Our Ref: P/33/26/DOC

Town & Country Planning Act 1990 (as amended)
Town and Country Planning (Development Management Procedure) (England) Order 2015
Approval of details reserved by condition under P/2/23/L relating to condition 3 (1.)- Windows & Doors.
Little Welbourne Church Lane Pagham PO21 4NX

Arun District Council have decided to **REFUSE details reserved by condition for the following reasons:**

CLIENT'S NAME  
**Mr & Mrs Bell**  
JOB TITLE  
**Little Welbourne  
Pagham**  
DRAWING TITLE  
**Proposed Window / Door Schedule**

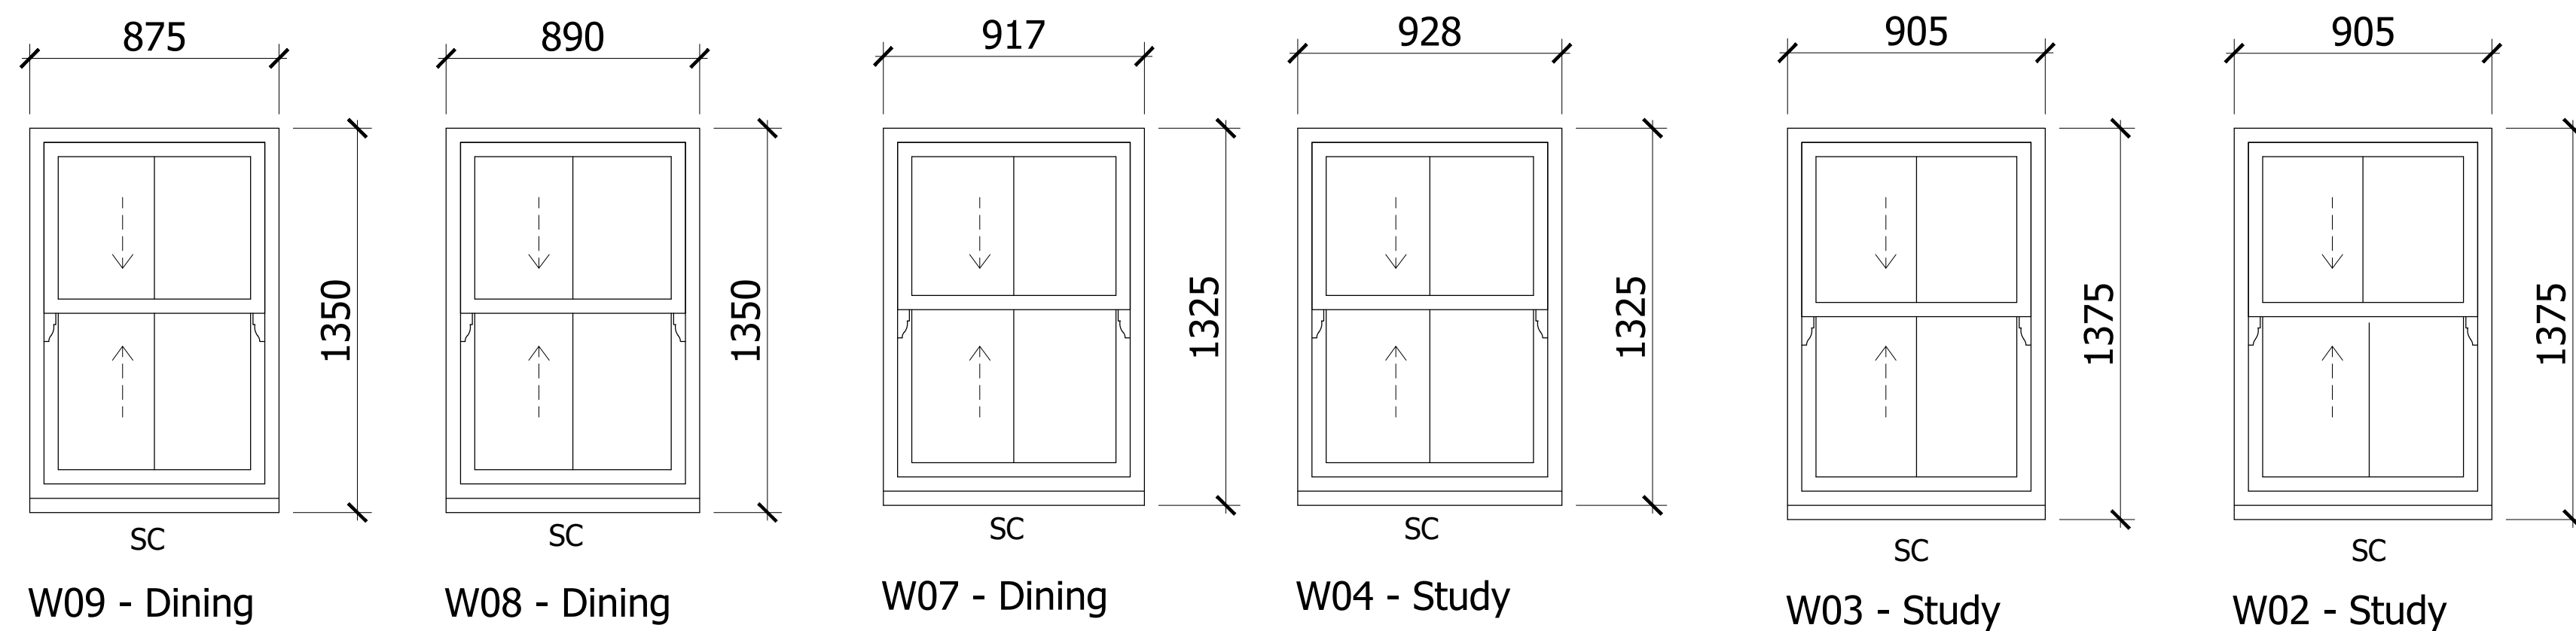
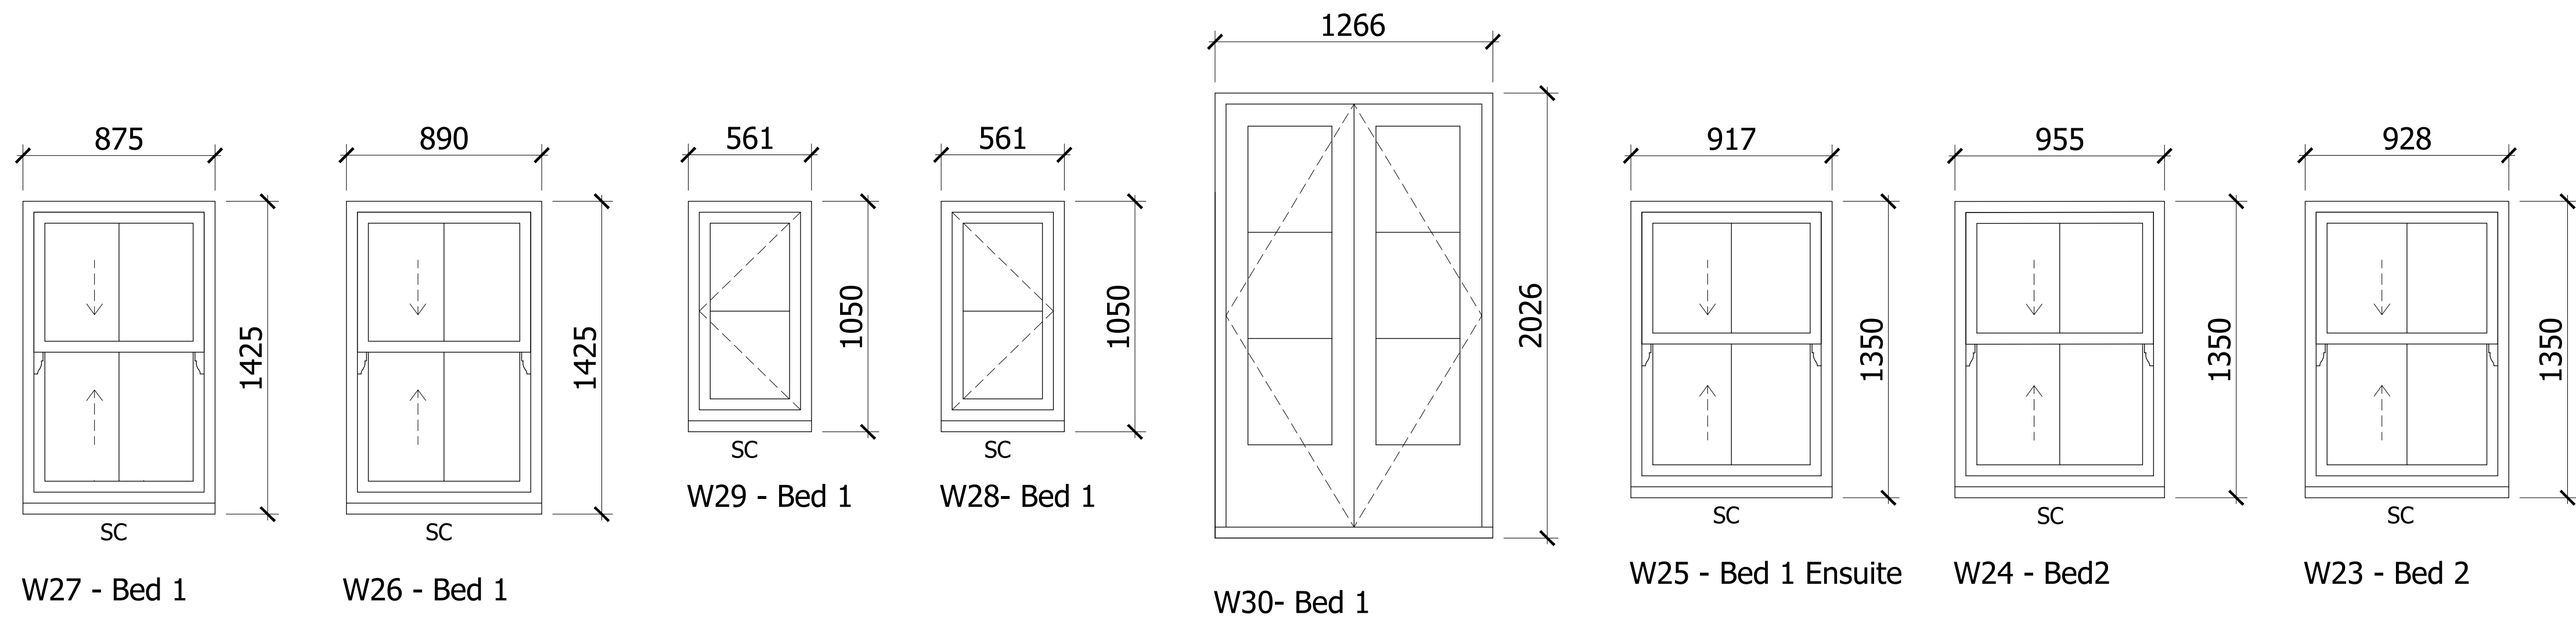
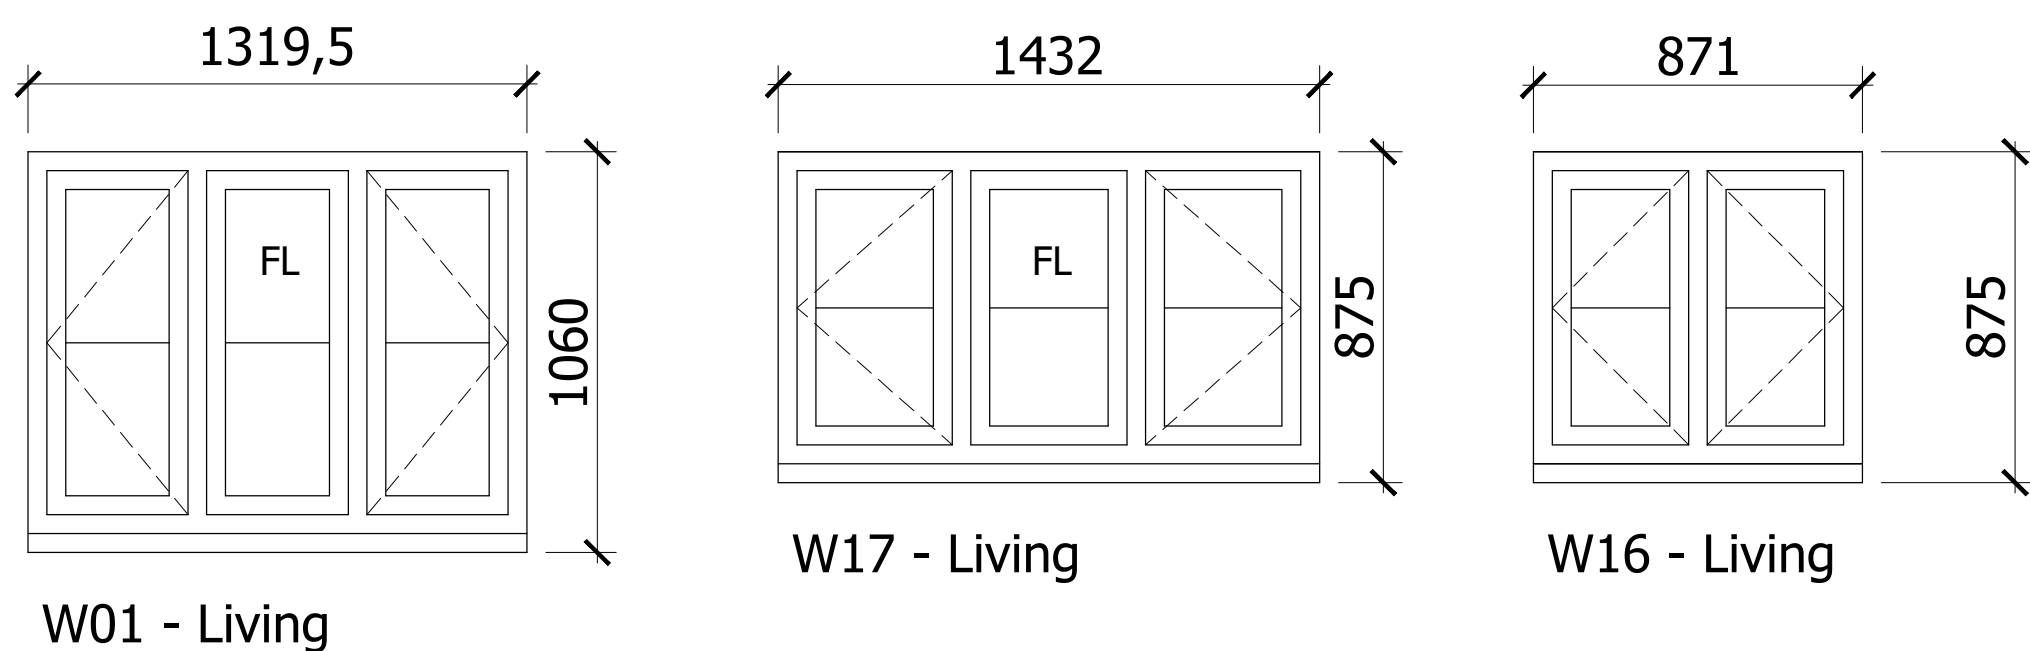
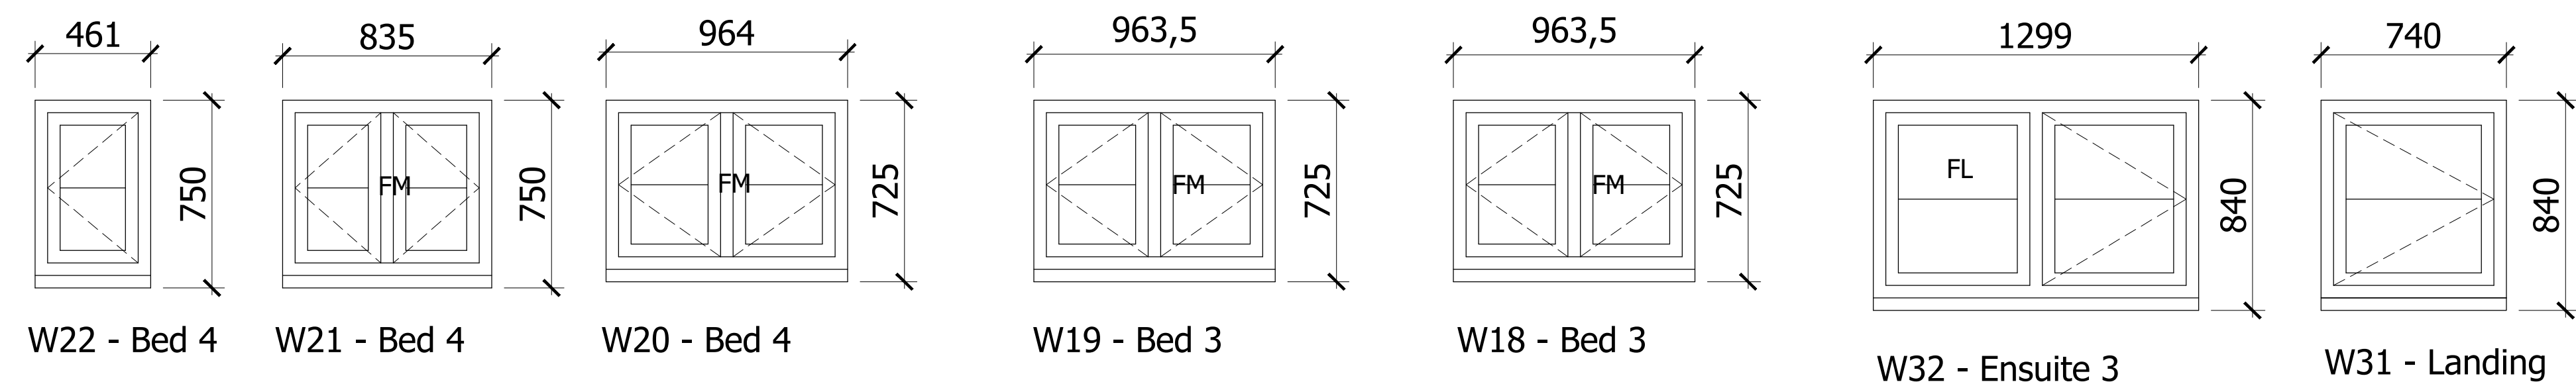
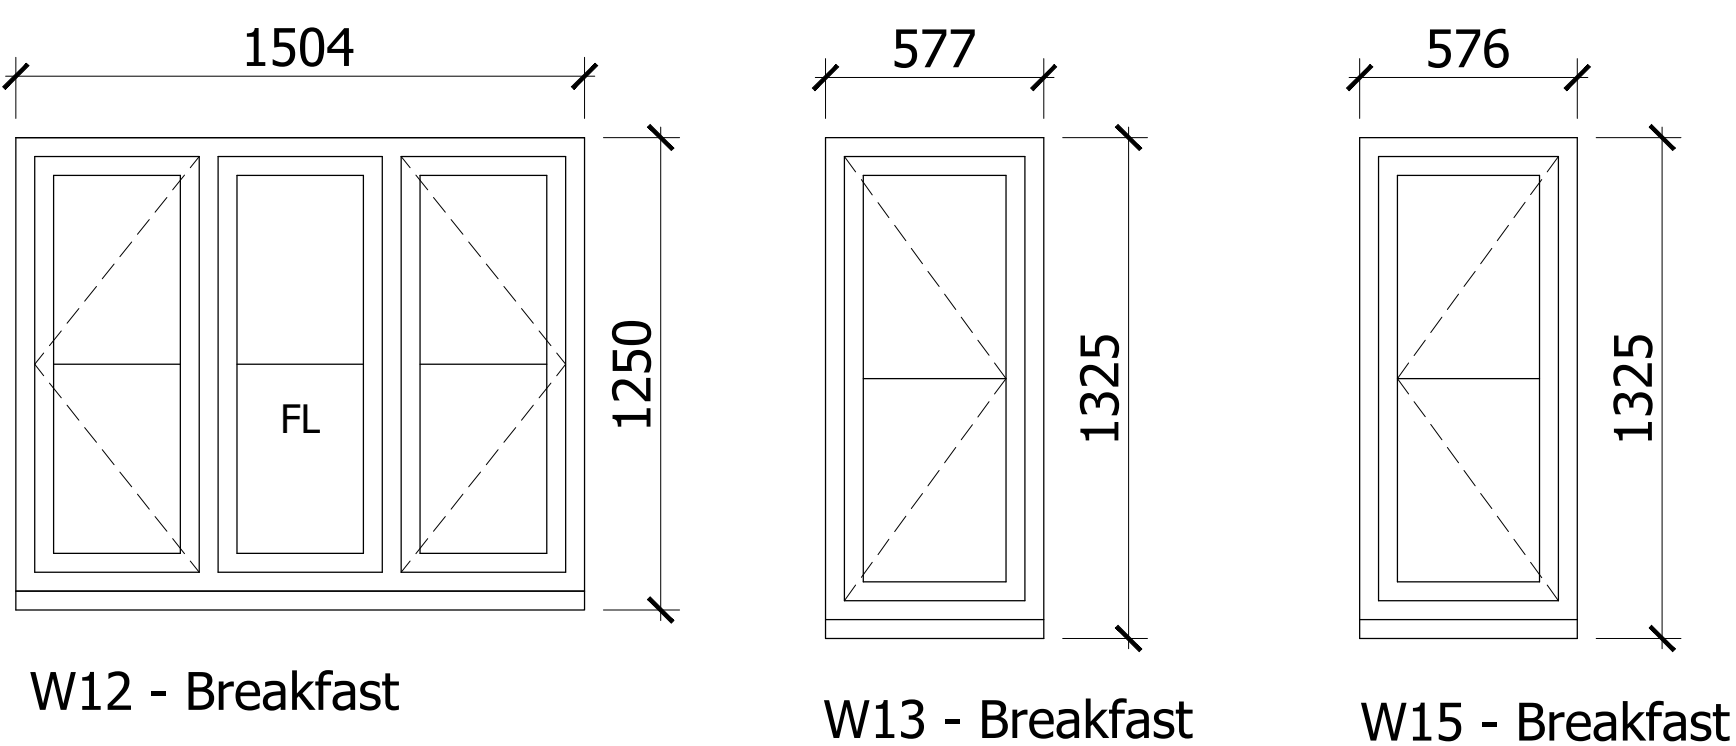
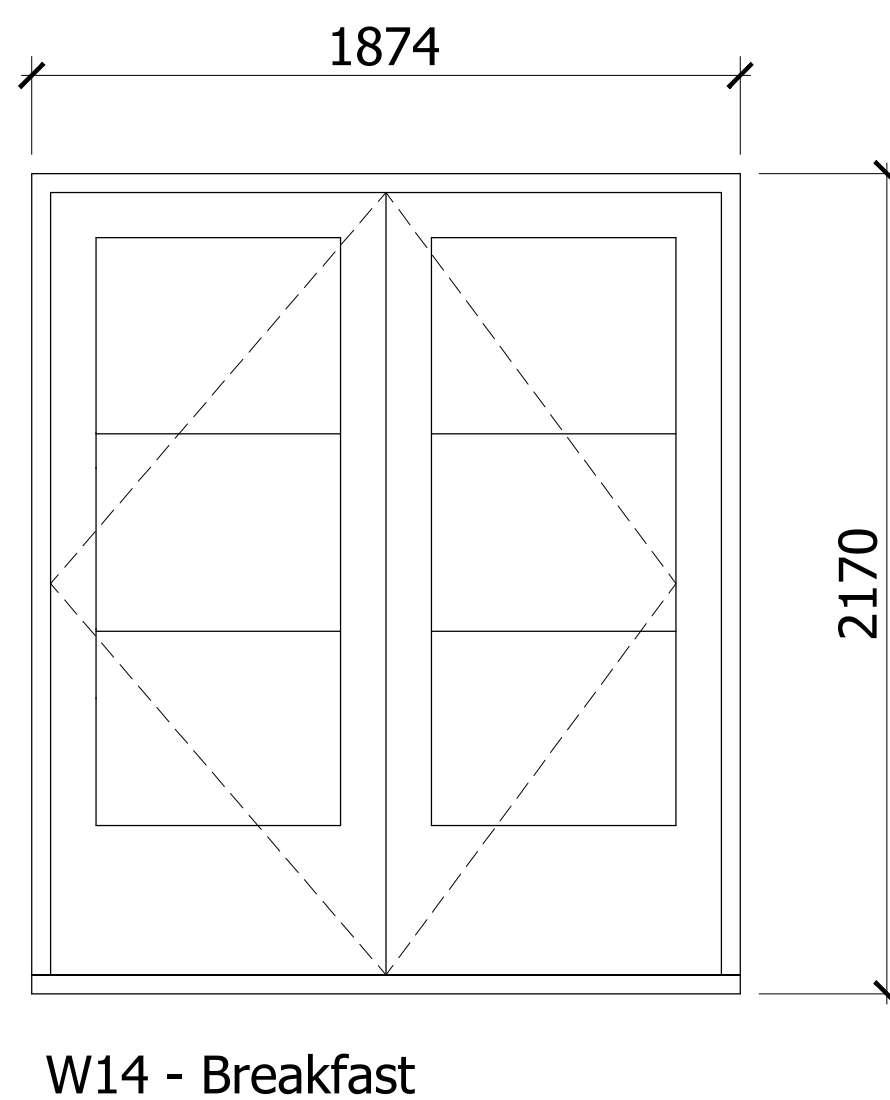
"The French doors are acceptable in principle, however the glazing bars are overly thick and would

appear visually heavy and dominant within the openings. This would not be appropriate, particularly if repeated across the building, and slimmer glazing bar sections are required. The overall joinery is also on the heavy side, although the primary concern relates to the glazing bar thickness."

The comments have been reviewed by officers and they are in agreement that the condition cannot be discharged at this time on the basis of the inappropriate details provided.
